## MMC Garage Preliminary Traffic Comments

Thu, Jul 5, 2018 at 10:22 AM

Hi Nell – I have conducted an initial review of the application materials and offer the following preliminary traffic comments.

FIRST FLOOR CODE INFORMATION PLAN

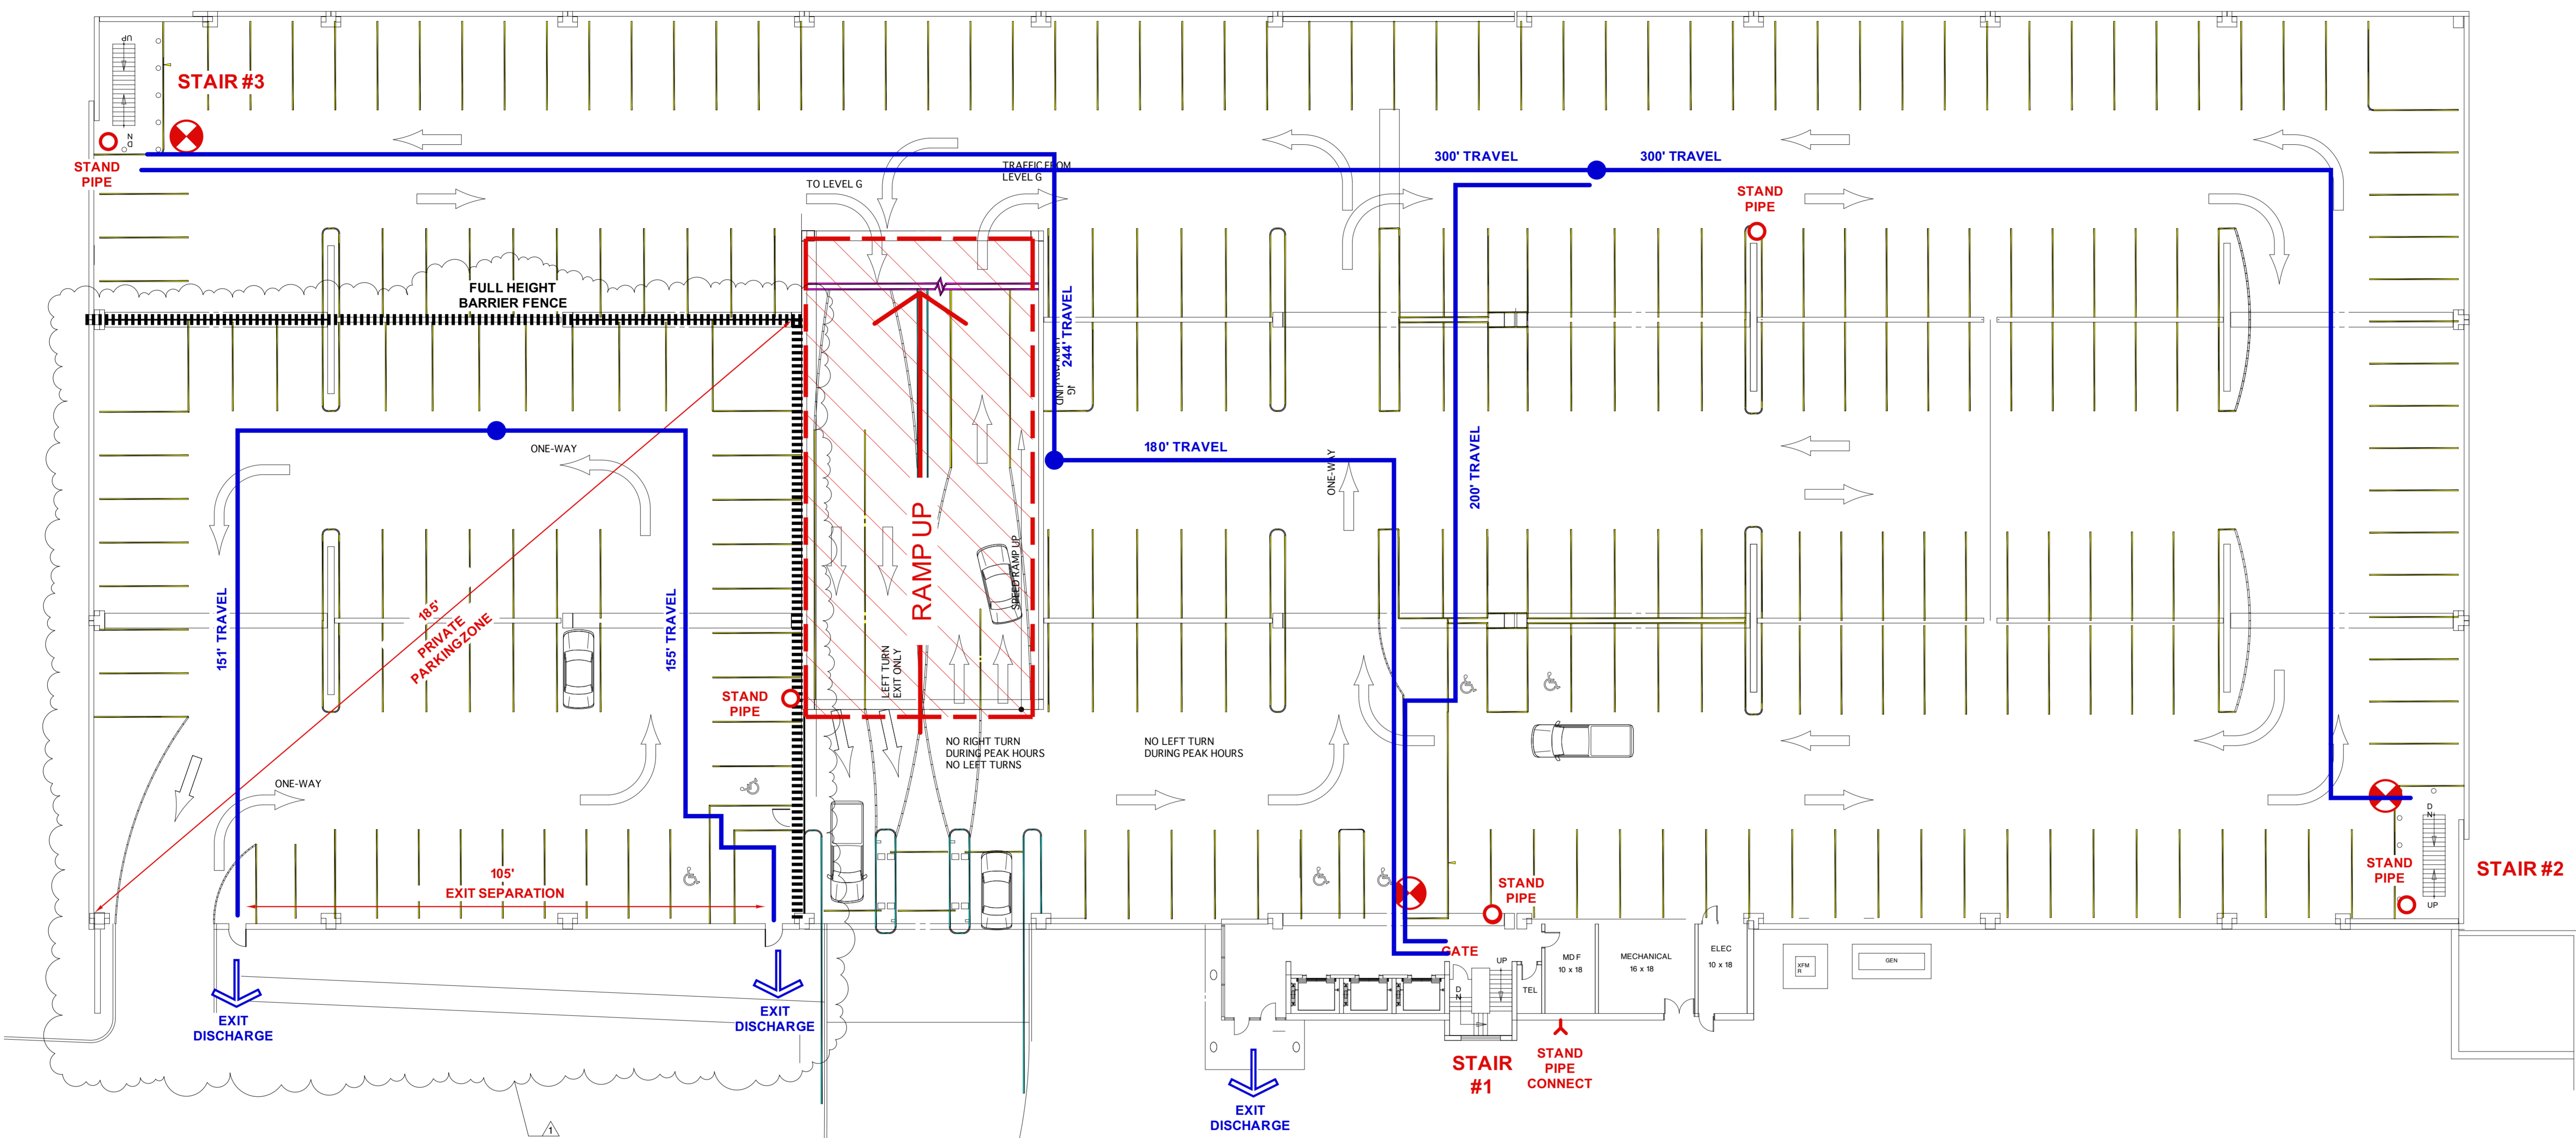
- The parking garage has a number of spaces that do not meet the City's dimensional standards for size. The applicant should request a formal waiver with supporting documentation.

- The garage plans should include dimensions for parking aisle widths.
- A traffic signal is proposed at the St. John Street/D Street/Garage Driveway location. I support the installation of a traffic signal given vehicle volume conditions and anticipate pedestrian movements. I would note that the applicant is responsible for development of design plans and equipment specifications for review and approval by the City. All costs associated with the installation of the traffic signal is the responsibility of the applicant.
